Our ref: 20SYD-16452

SSD 10479 Response to submission - DPIE – Biodiversity comments

Eco Logical Australia has reviewed the DPIE comments and provided input to design changes to address the comments from DPIE. The responses below are based on the revised concept contained in Attachment 1.

Figure 4: Validated watercourses within study area

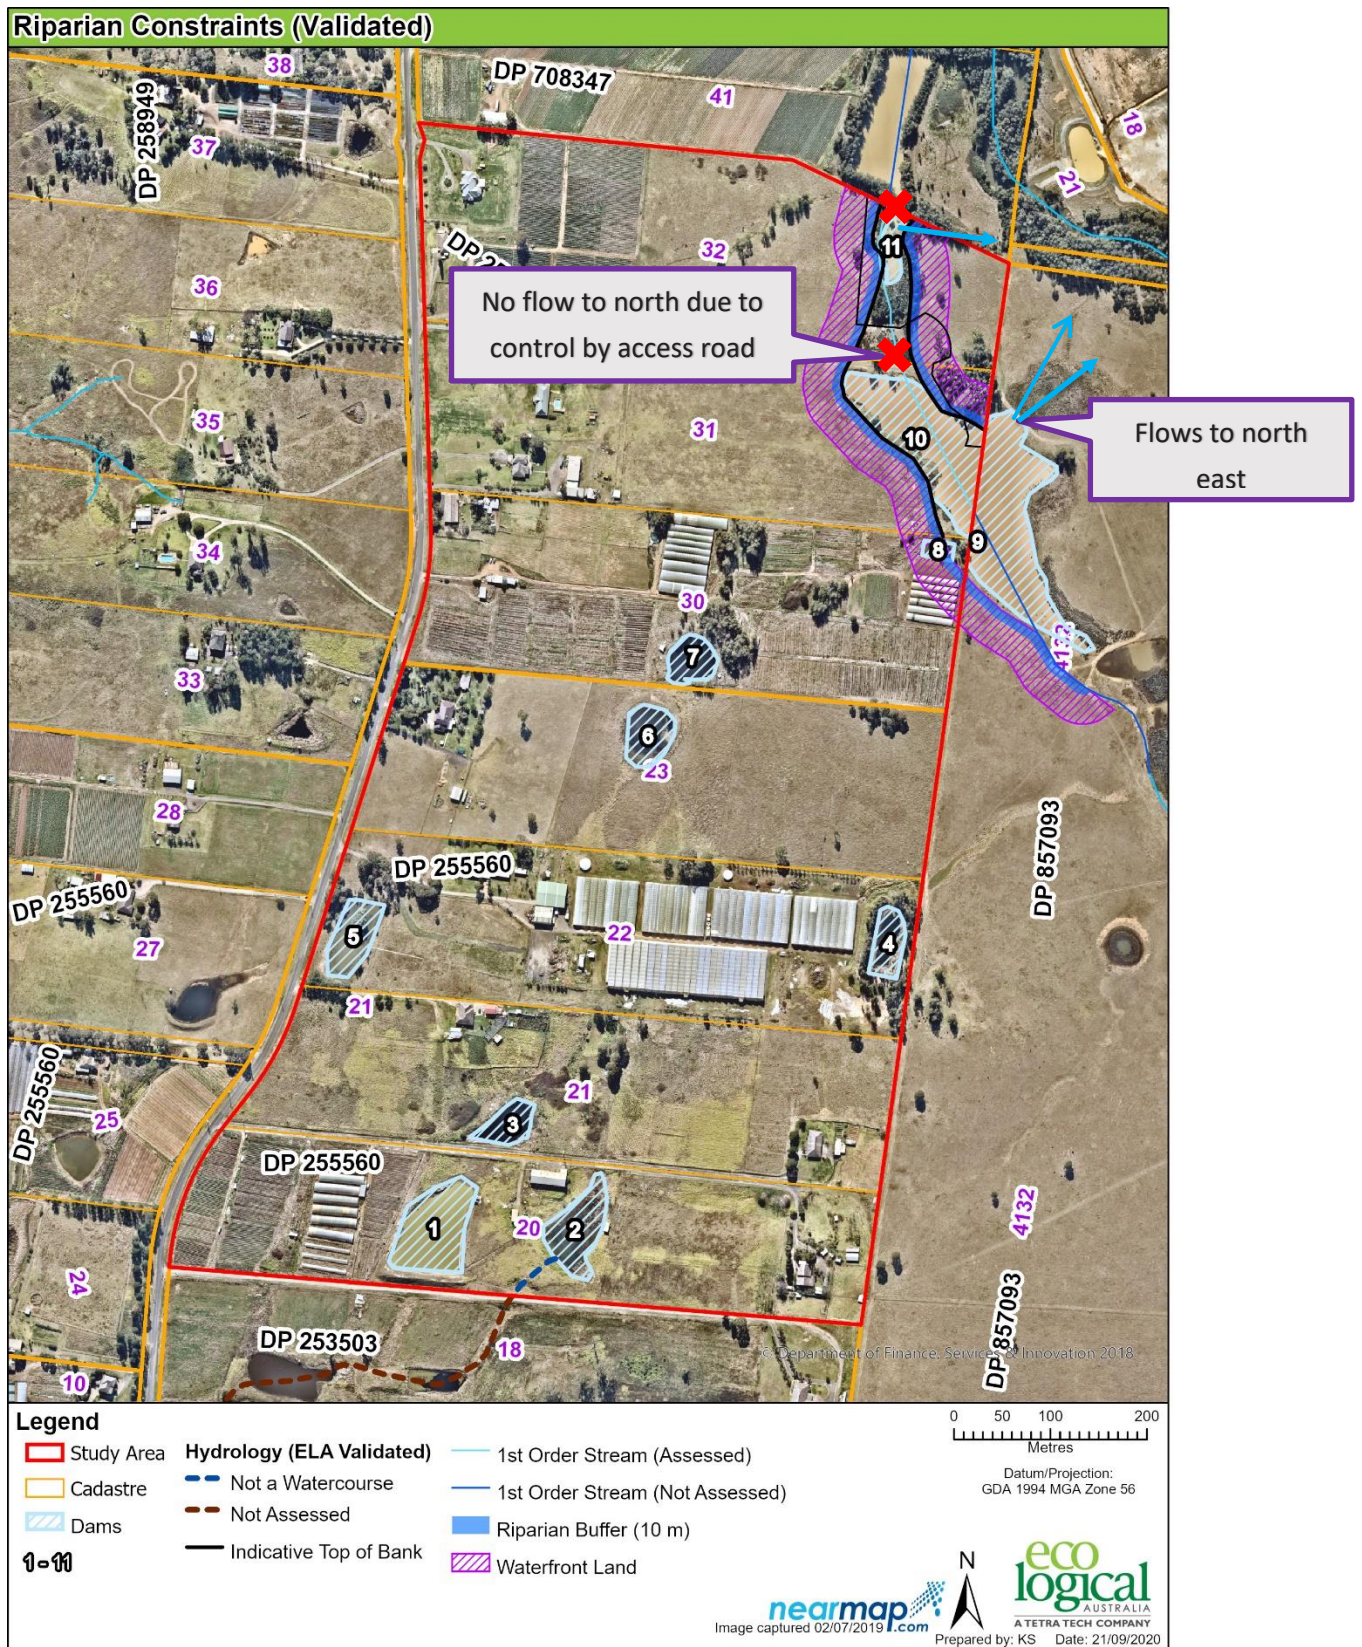
Biodiversity and Conservation Division	
As previously advised, the north eastern corner of the site is zoned E2 Environment Conservation and RE2 Private Recreation. The Mamre Road Precinct Structure Plan identifies this area as open space, environment conservation and indicative riparian buffer. Regarding the environment conservation land, the precinct structure plan states that this is “land to be protected for its high conservation value and supported with surrounding buffers”. The EIS indicates that part of warehouse W6, carparking and a basin impact and encroach into the RE2 zoned land. Within the RE2 zone, warehouse and basin uses are prohibited. The proposed development is therefore inconsistent with the structure plan and zoning regime applying to the site	The north east corner has been re-designed to retain the entry and exit points of the 1st order watercourse through this part of the site. See attached diagram.

Figure 16: Proposed development footprint

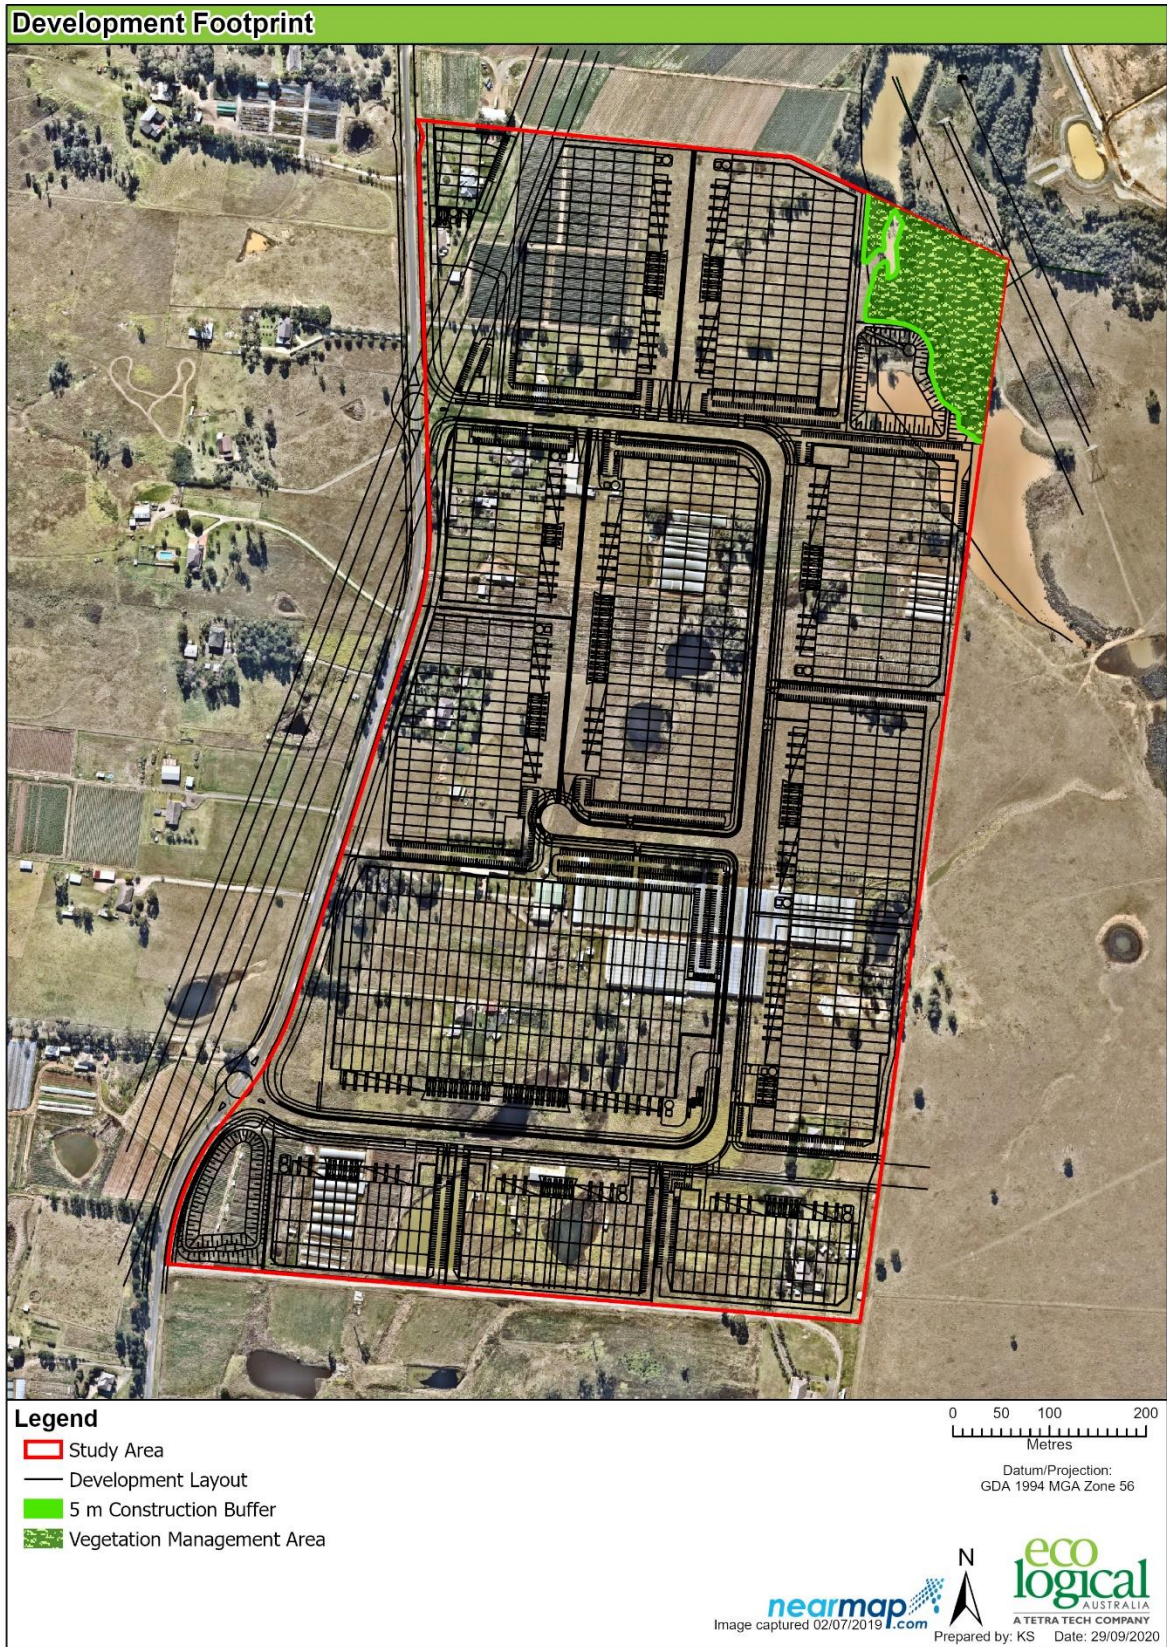
In conjunction with this, reconsideration of the types of habitat available for microbats on the site is needed. For example, Table 15 of the BDAR states for <i>Miniopterus orianae oceanensis</i> (page 34) “Foraging habitat features associated with this species were identified within the development site” but human-made structures can also provide habitat for this species because “Caves are the primary roosting habitat, but also use derelict mines, storm-water tunnels, buildings and other manmade structures”	See above
Assessment of impacts – It is not clear if all impacts associated with the proposal have been assessed in the BDAR. This is because: • Figure 16 of the riparian assessment shows the “unmapped wetland” (as shown on Figure 3 of the BDAR) to be part of the construction site, but Figure 3 of the BDAR shows it to be outside of the development footprint • the riparian assessment states that the actual works within the riparian corridor have not been fully documented, and that a crossing is proposed (see page 27), but neither of these points are referred to in the BDAR and it seems that the location of the crossing has not been shown • from a comparison of Figure 3 of the BDAR, Figure 16 of the riparian assessment and Appendix A of the riparian assessment, it is not clear if vegetation zones 1 and 4 will be impacted by the bio-retention basin in the north eastern corner of the development site (on proposed Lot D) • the SSDA Estate Masterplan (drawing no. MP04, date 01/10/2020) and the Fencing Management Plan (drawing no. MP11, date 01/10/2020) show several retaining walls on Lot D but it is not clear if these will impact the “unmapped wetland” (as shown in Figure 3 of the BDAR) or PCTs 1232 or 835 • it is not clear if the 5m construction buffer (as shown in Figure 3 of the BDAR) is compatible with the construction of the retaining walls and bio-retention basin (as shown on drawing no. 19-609-C1020 of the 200 Aldington Kemps Creek 1000-Series Infrastructure Civil Works Package State Significant Development Application (at&I, 30-09-20)).	The proponent has redesigned stormwater infrastructure and habitat retention in the north east corner of the site in order to improve riparian outcomes. The proposal will re-create a watercourse through the site to join the first order stream to the unmapped wetland which will be retained. See attached diagram. A creek crossing is no longer proposed. Figure 10 and 11 of the BDAR show impacts to vegetation. The redesign mentioned above does not increase these impacts. Attached diagram shows redesigned concept for the north east corner.

As such, all impacts of the proposed development must be made clear in the BDAR and assessed in accordance with Stage 2 of the BAM.	Impacts have been assessed in accordance with the BAM
Avoiding and minimising impacts – The ways in which the proposal has been located and designed to minimise and avoid impacts to biodiversity values are outlined in Tables 18 and 20 of the BDAR. However: • Table 18 states “The impact of the proposal on native vegetation has been reduced by locating the sediment dam in a way that minimises impact to PCT 835” but no mention has been made of other	The design of the stormwater infrastructure and riparian corridors has been updated. See attached.

Comment / Extract	Response
impacts within the riparian corridor, including clearing of a portion of PCT 1232, which forms part of an endangered ecological community and Table 20 states “The dam in the northern-most section of the site had moderate levels of aquatic habitat and was representative of a wetland environment. This dam will be retained after development, and the surrounding vegetation managed to maintain habitat values.” But no mention is made of infilling dam 10, which also occurs within the riparian corridor and provides habitat for the GGBF (as inferred by the riparian assessment, which notes that <i>Typha orientalis</i> was observed on the edges of the dam).	
As such, in accordance with section 8 of the BAM, more information is needed to document and justify the location and design of the project.	See above. Stormwater infrastructure has been redesigned in the north east corner.
